23 Upper Drive, East Preston

Planning Application EP/124/20/HH

Below are my objections and comments relating to planning application EP/124/20/HH.

Drawing Name
Elevations-
Proposed

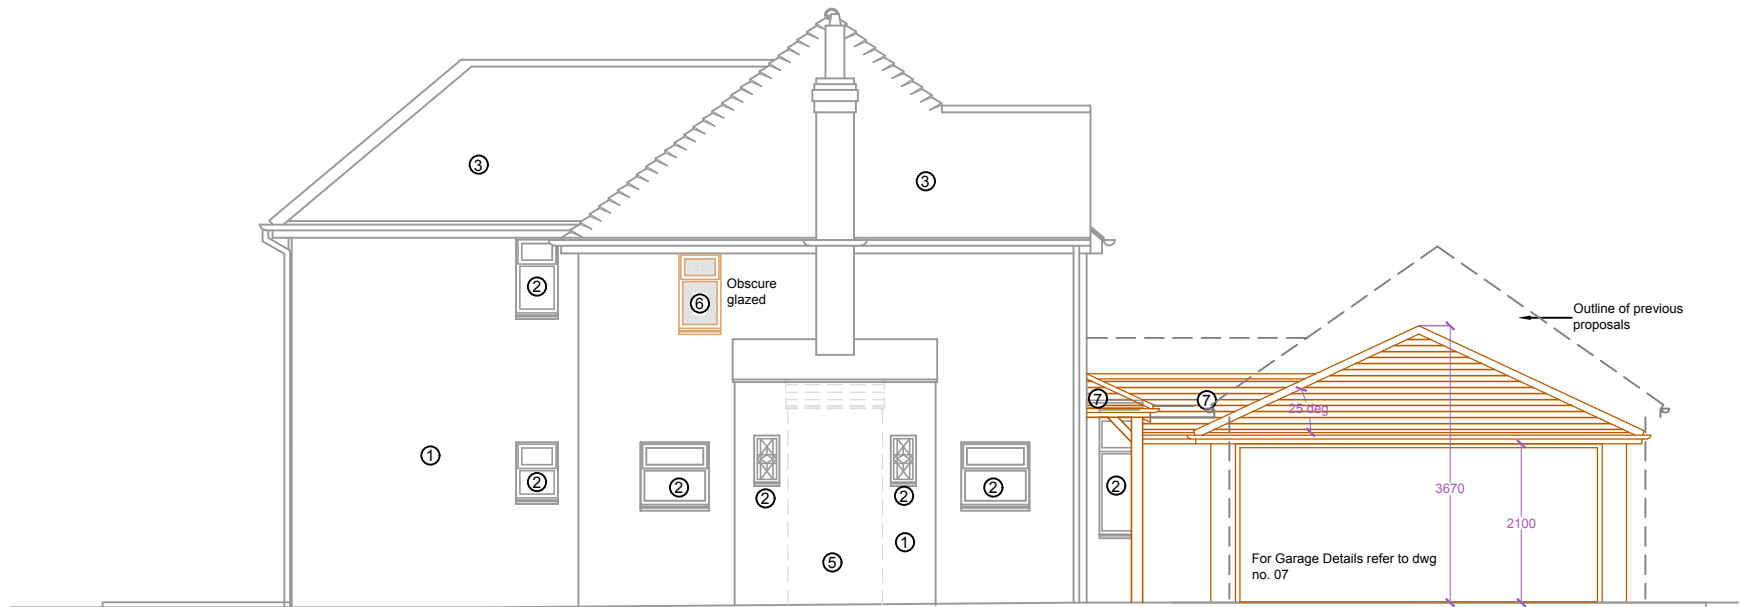
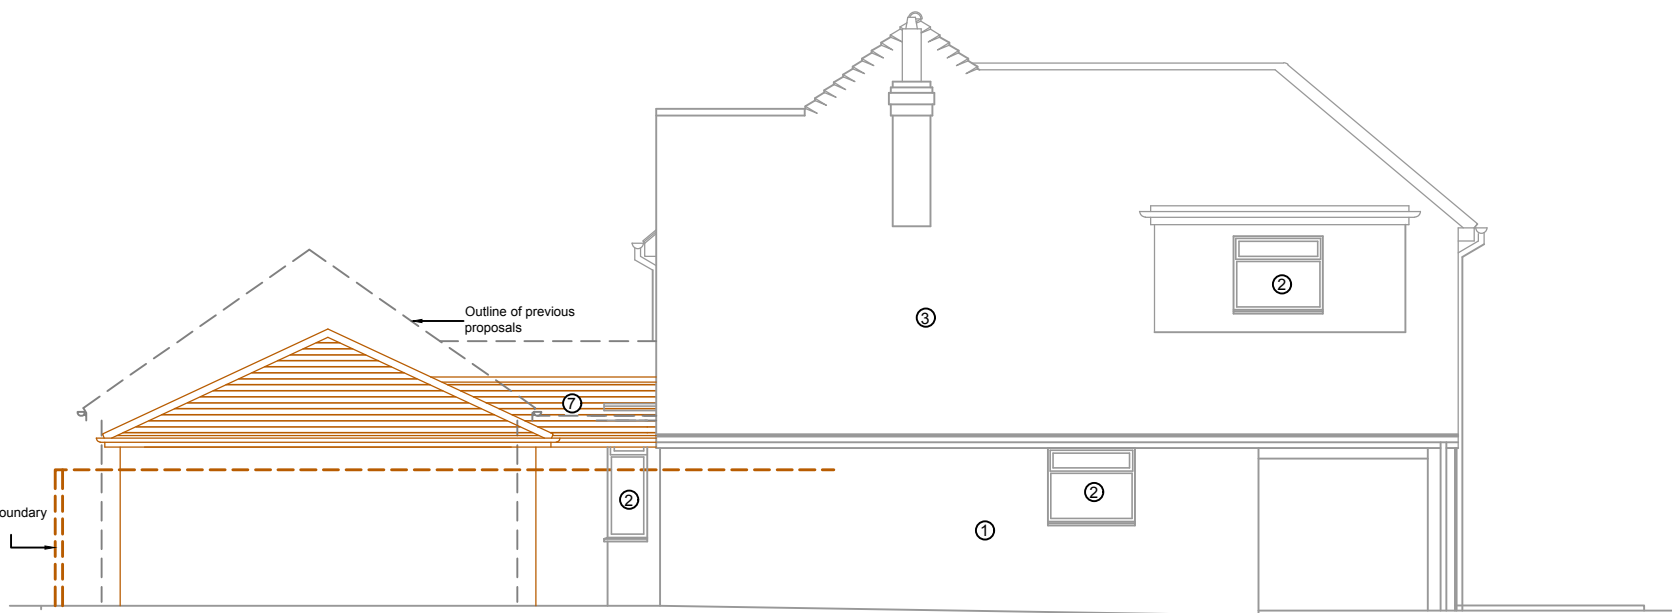
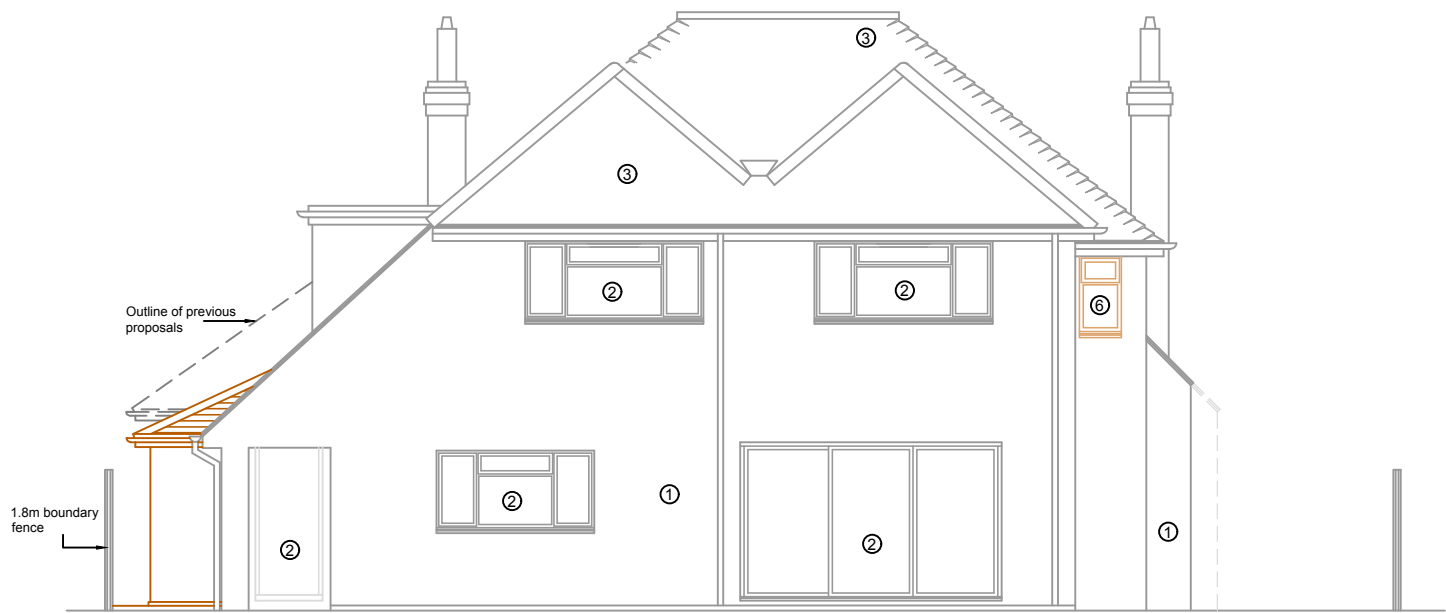
10. Conversion work is being done to the bedrooms which involves 2 new windows as shown on Drawing 203075/03. The proposed bedroom windows on the upper floor of the south elevation overlook the gardens of 21 Upper Drive and 59 Manor Road. They also overlook the living space of 59 Manor Road. Whilst the proposal includes one being opaque glass this could be changed at any time in the future.

203075/ 03

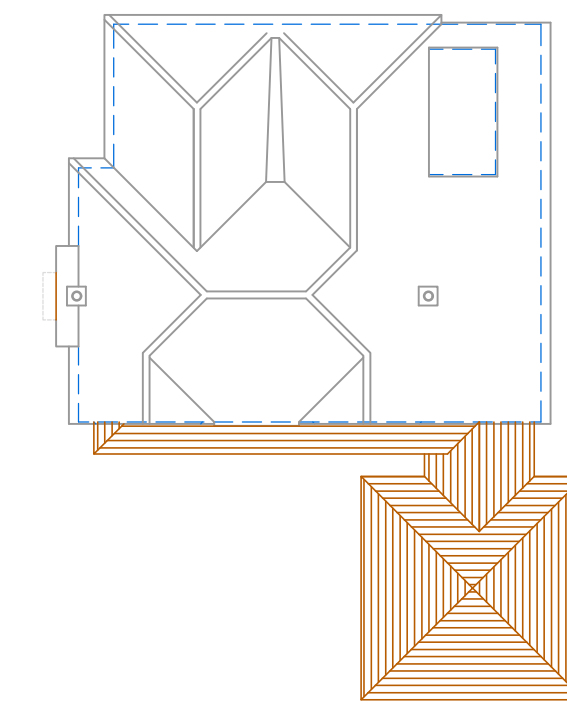
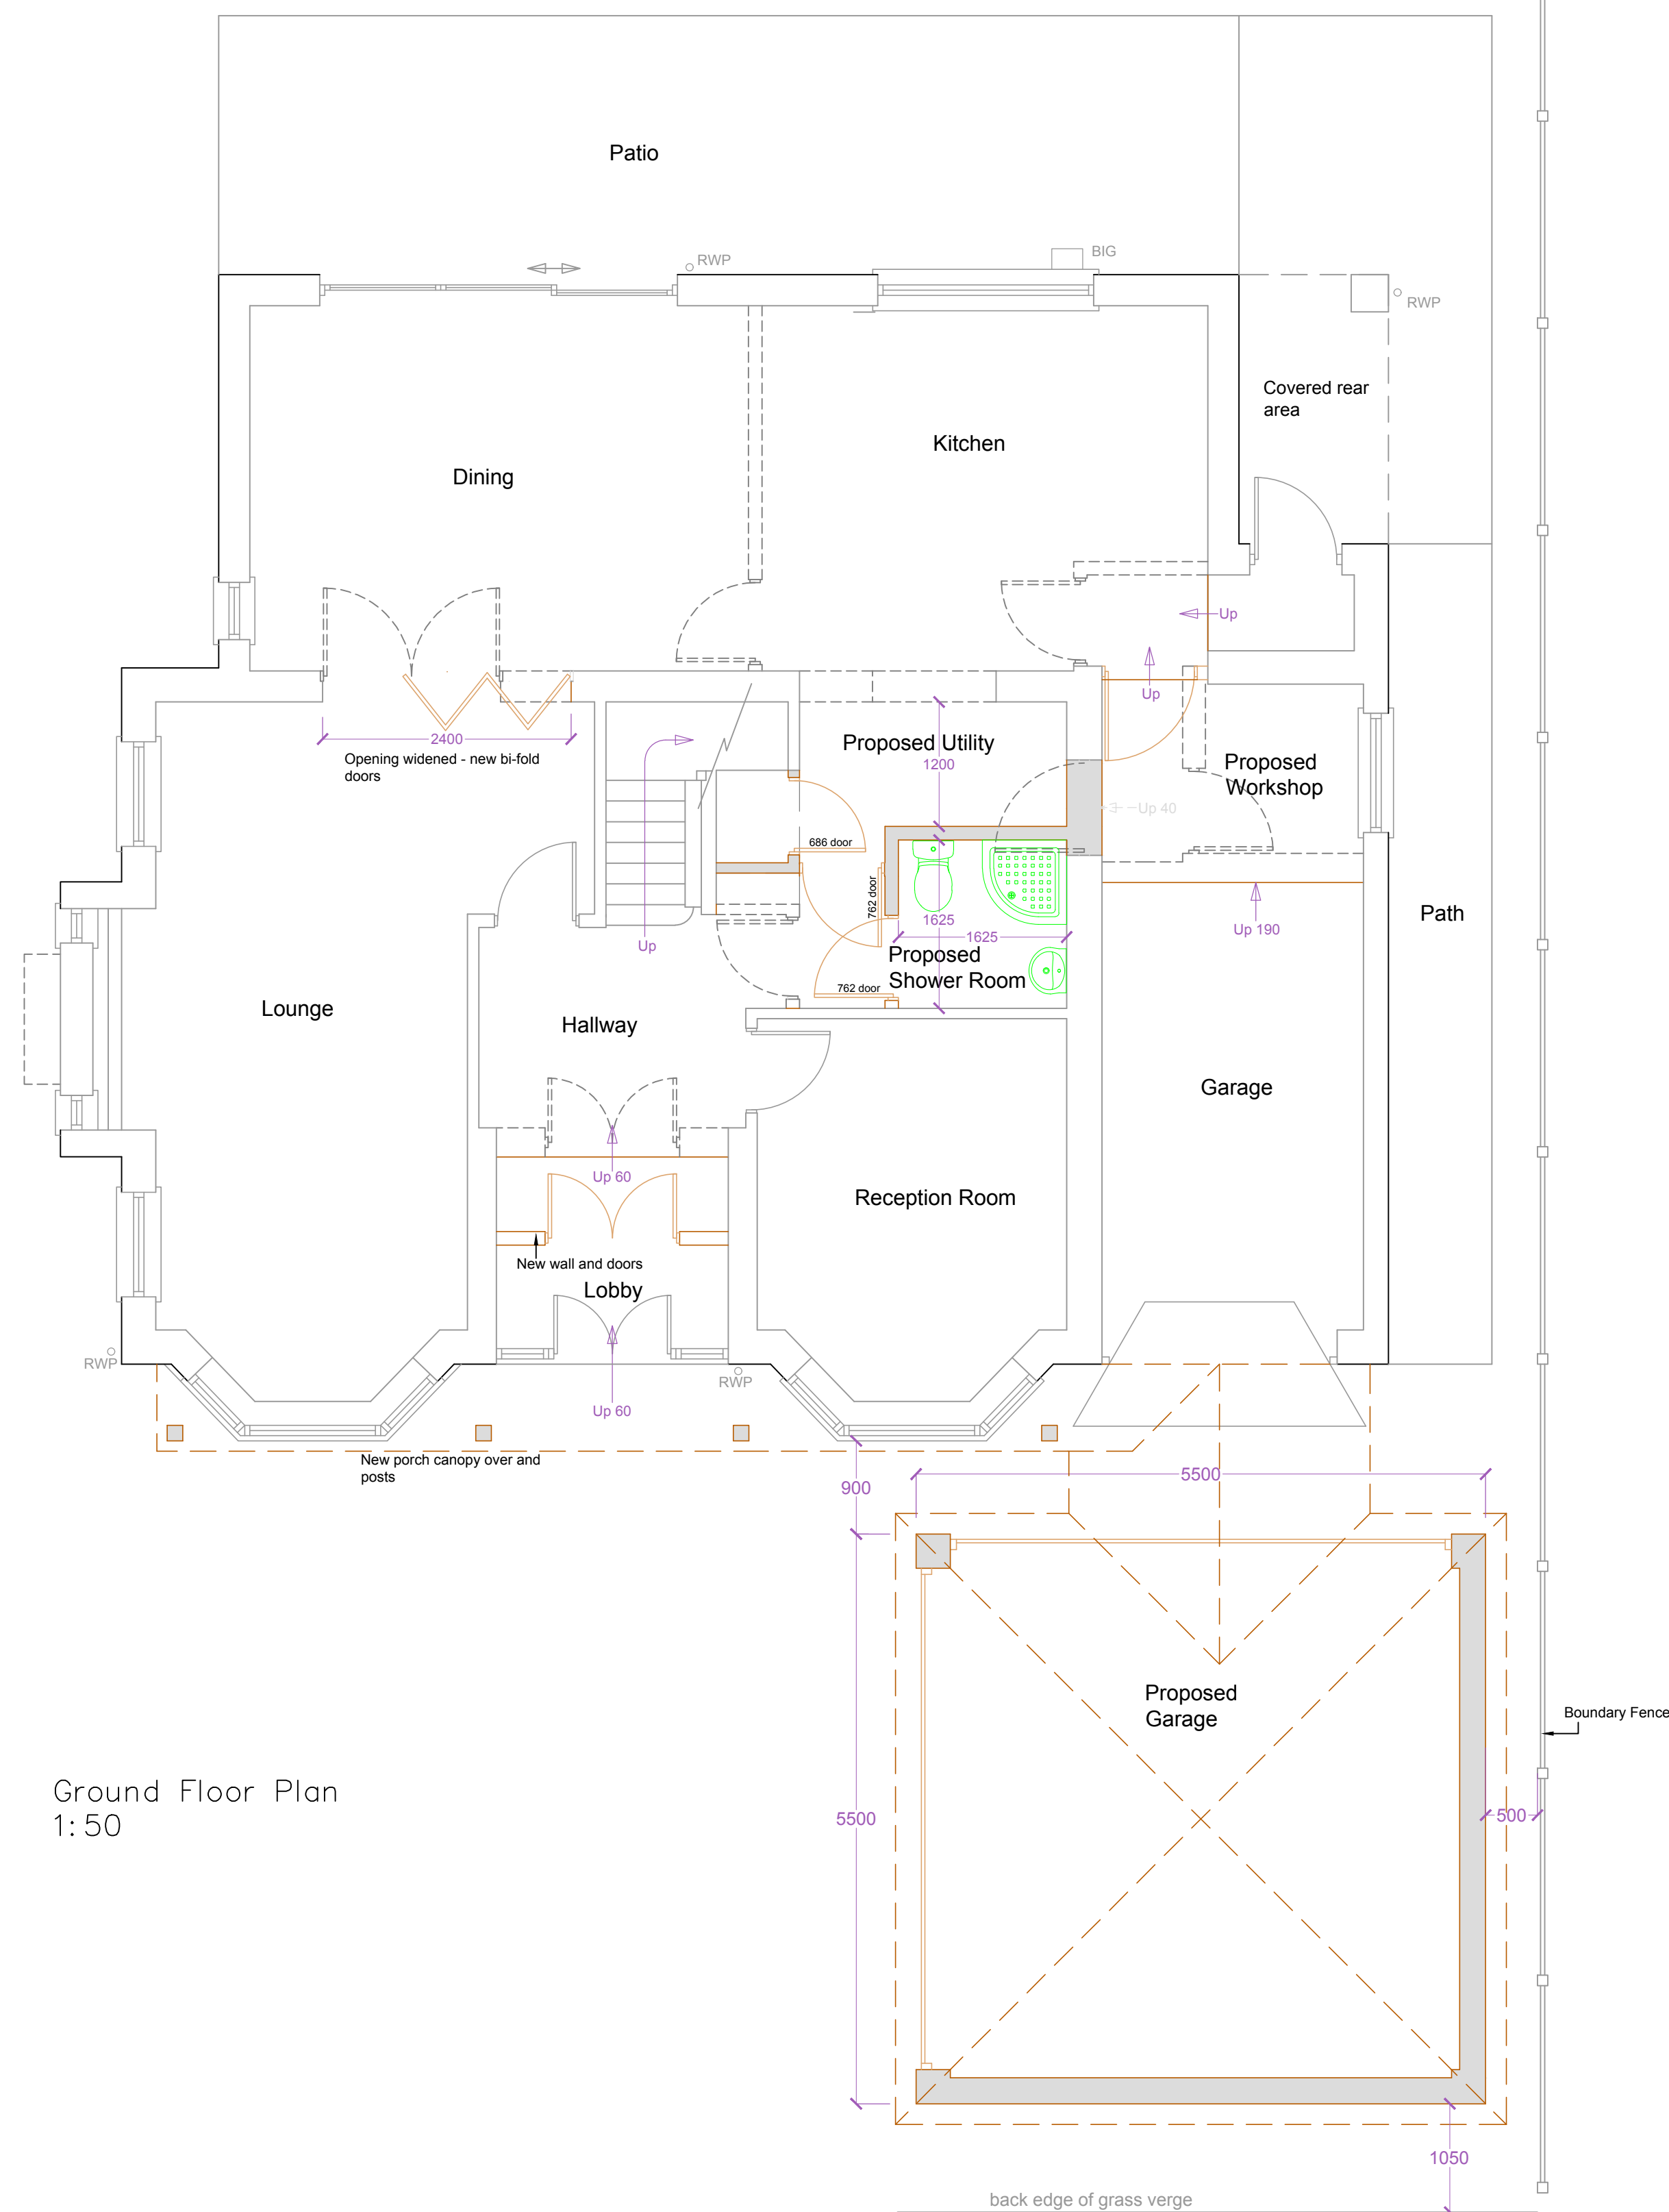
The proposed garage is only 500 mm, at ground level, from the boundary of 25 Upper Drive, as shown in Drawing 203075/03. There appears to be a roof overhang of 200mm or more (based on an unidentified dotted line on the plan). I expect there will be guttering (although this is not shown on the plan) which would bring the structure to approximately 100mm of the boundary.

13. The existing floor plans (203075/01) show a dining room on the north side of the ground floor of the property, the proposed floor plan and roof plans (203075/03) show this room to be a garage.
It is in fact an integral garage.

Garage Plans and Elevations -
Proposed

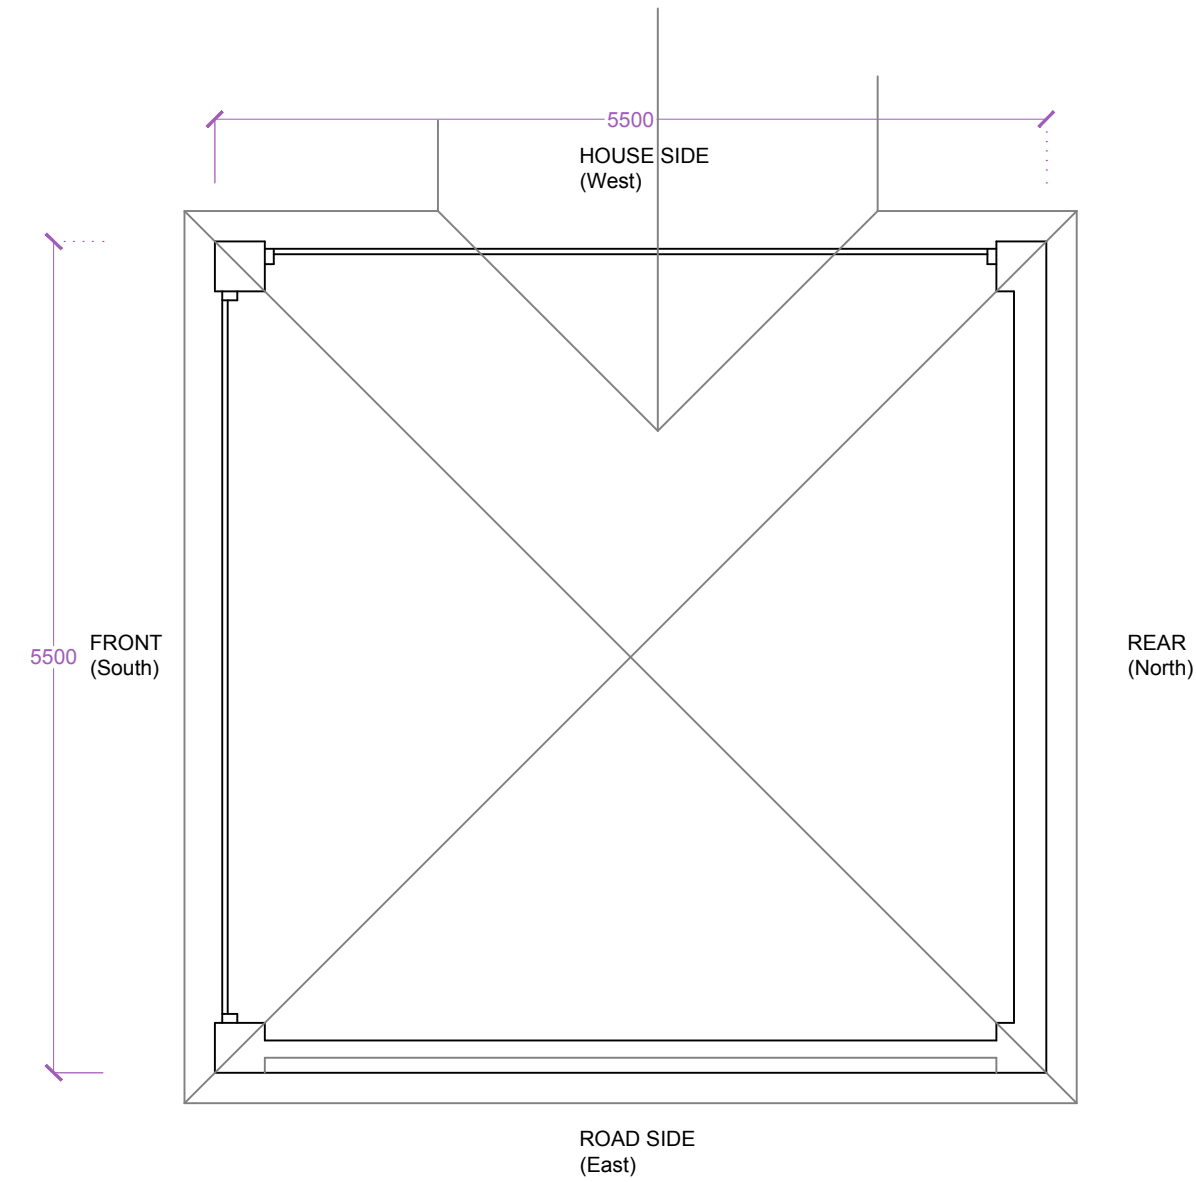
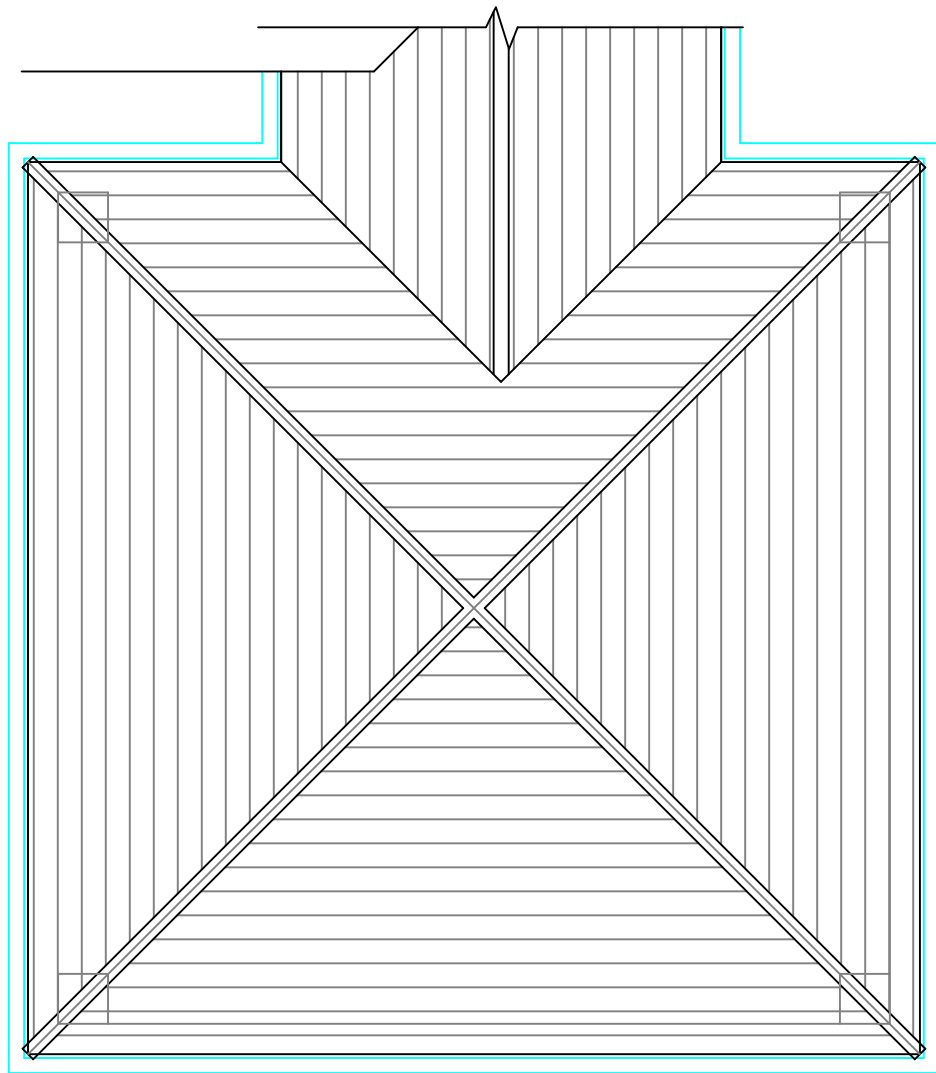
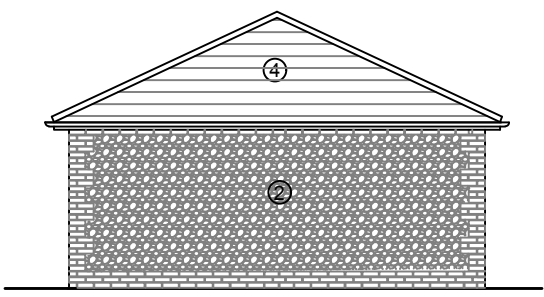
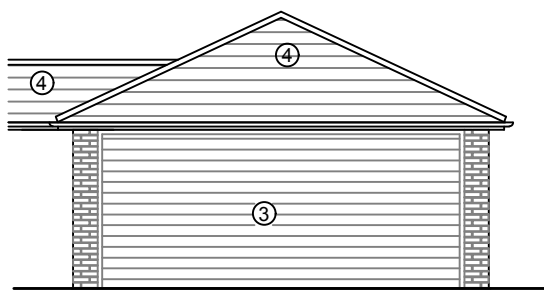
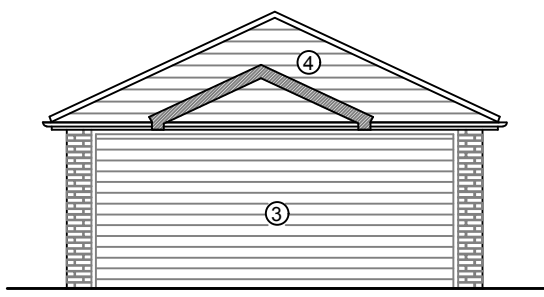
The proposed garage is a large structure (5.5m x 5.5 m x 3.67 m) in the front garden. It is beyond the building line and out of character with the area to the detriment of the local environment.

The proposed garage would be an imposing structure on the street scene. It is in front of the existing building line, no other properties in the street have structures in front of the building line.

- a. The proposed garage is 3.67 metres high, this will significantly reduce light to 25 Upper Drive.

- b. The design means that the 45 degree rule is not met, the purpose of this rule is to safeguard adequate sunlight and daylight to adjacent properties and protect them from overshadowing.

A building 5.5 metres x 5.5 metres and 3.67 metres high has the potential to be used for things other than a garage, such as a workshop.
